Thornley – Knott Farm Barn

Proposed Conversion to Single Dwelling

Planning Application ref. No. 3/2023/0367

Planning Appeal Statement

PROPOSED NORTH EAST ELEVATION (1 : 100)

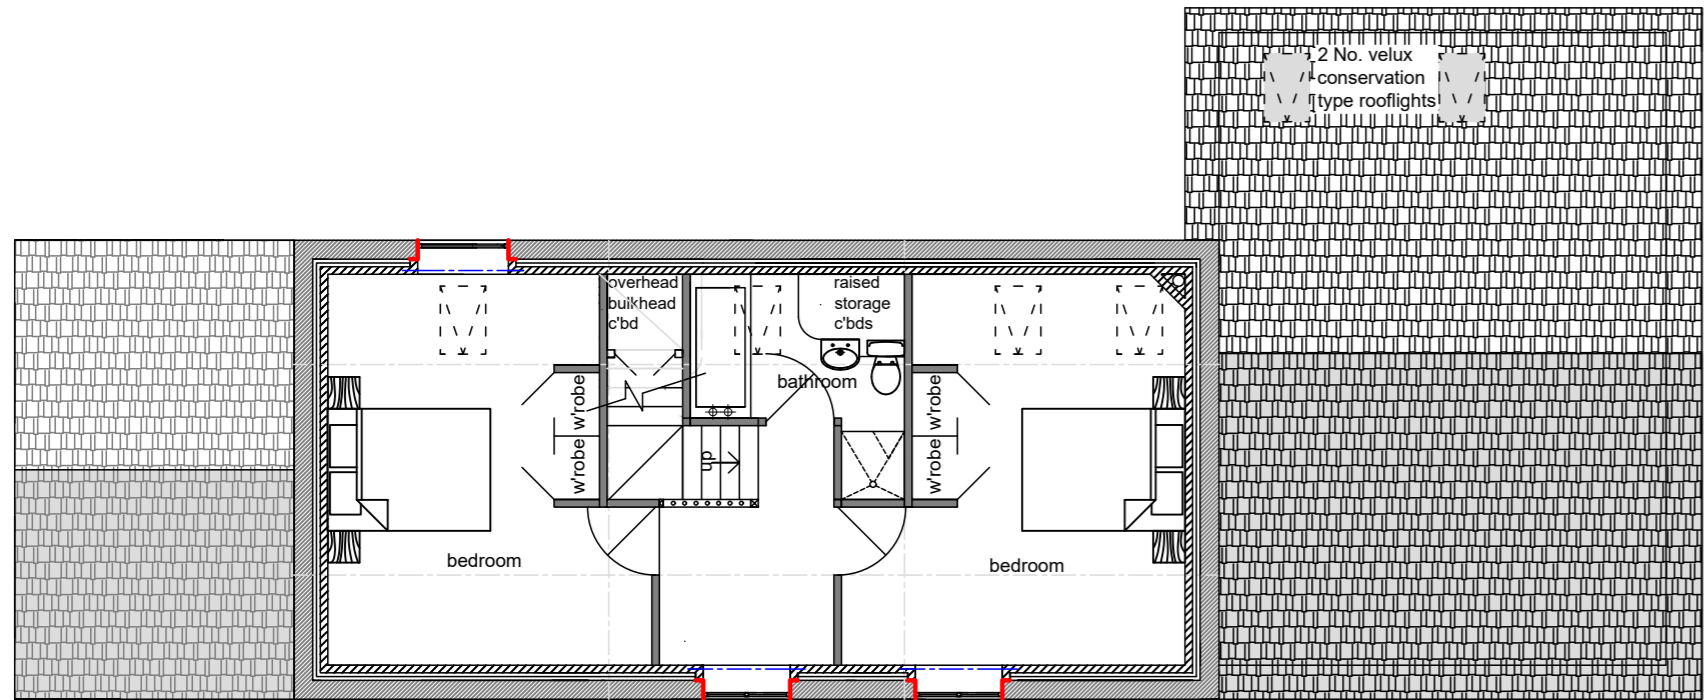
- 1. **The cumulative number and nature/configuration of the openings on the north east elevation undermines the inherent character of the building with the introduction of the large central glazed element also considered to be incongruous and unsympathetic.***

The larger central glazed element in the proposed north east elevation was intended to provide natural light into the large internal entrance hall areas. It was also intended to reproduce the existing larger opening to the more modern steel framed extension at the north end of the barn. As such, we did not consider this element to be incongruous or unsympathetic, however, in view of your comments we have agreed to delete this larger opening and reinstate the existing single door and window openings into the proposed new internal entrance hall. The single door opening has been retained in its existing location but the existing window opening has been re-located very slightly to align with the existing opening at first floor level above and directly alongside the door. This revision is shown on the attached amended drawing No. 3526-004 Rev H.

In addition, we have deleted the proposed new bedroom window opening at first floor level to the north of the existing opening.

There are 2 No. proposed windows to the kitchen and side entrance porch in the replacement of the existing modern steel framed extension at the north end of the building, and these are necessary to provide natural light into these rooms with no option to do so at the rear since this wall is a boundary.

All other external door and window openings in this north east elevation are existing and are proposed for retention.

PROPOSED SOUTH WEST ELEVATION (1 : 100)

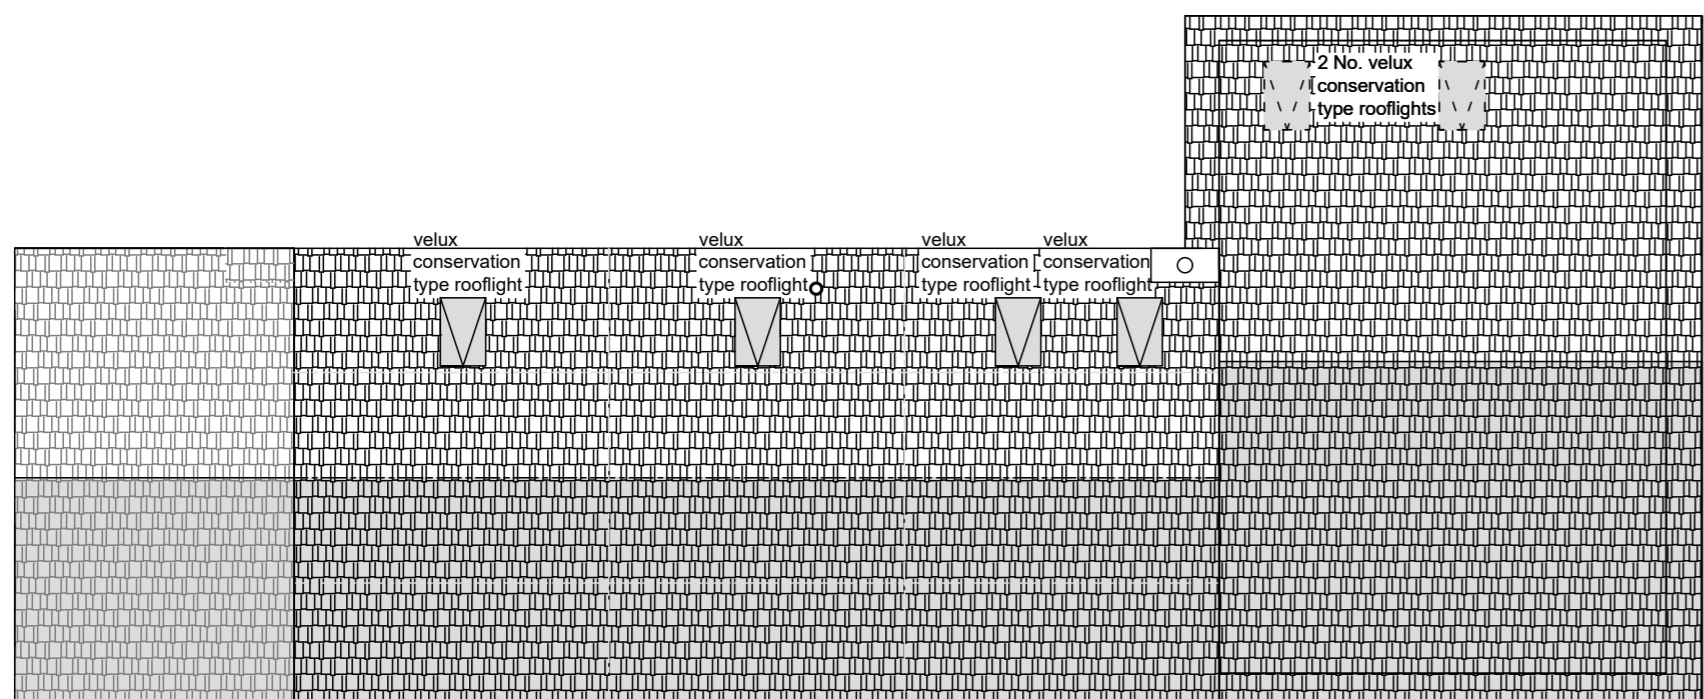
2. *The cumulative number and proportioning/configuration of the openings on the south west elevation, in concert with the excessive number of rooflights would result in a form of development that fails to protect or enhance the character of the existing building in its current form*

The existing south west elevation currently has no door or window openings and this is not considered either practical or desirable to facilitate a successful conversion of this building for domestic use.

With regard to your comments we have deleted the proposed ground floor window located near the bottom of the staircase.

The first floor north bedroom window which we originally located in the north east elevation (refer Item 1 above) has been re-located to the private south west elevation at the rear, so that each of the two first floor bedrooms has a window at the rear providing natural light.

We have retained the double glazed doors around the central part of the south west elevation to provide natural light into the main entrance hall and living areas at the rear of the building in an area which is entirely private and not visible to any other nearby property or access point.

The north and south annex ends of the south west elevation have been maintained entirely free of door/window openings.

There are currently at least 3 No. larger rooflights in the existing roof together with several smaller glazed openings. We have revised the attached amended drawing No. 3526-004 Rev H to show 3 No. conservation type roof lights in the main two storey part of the building, reduced from the original 4 No. proposed.
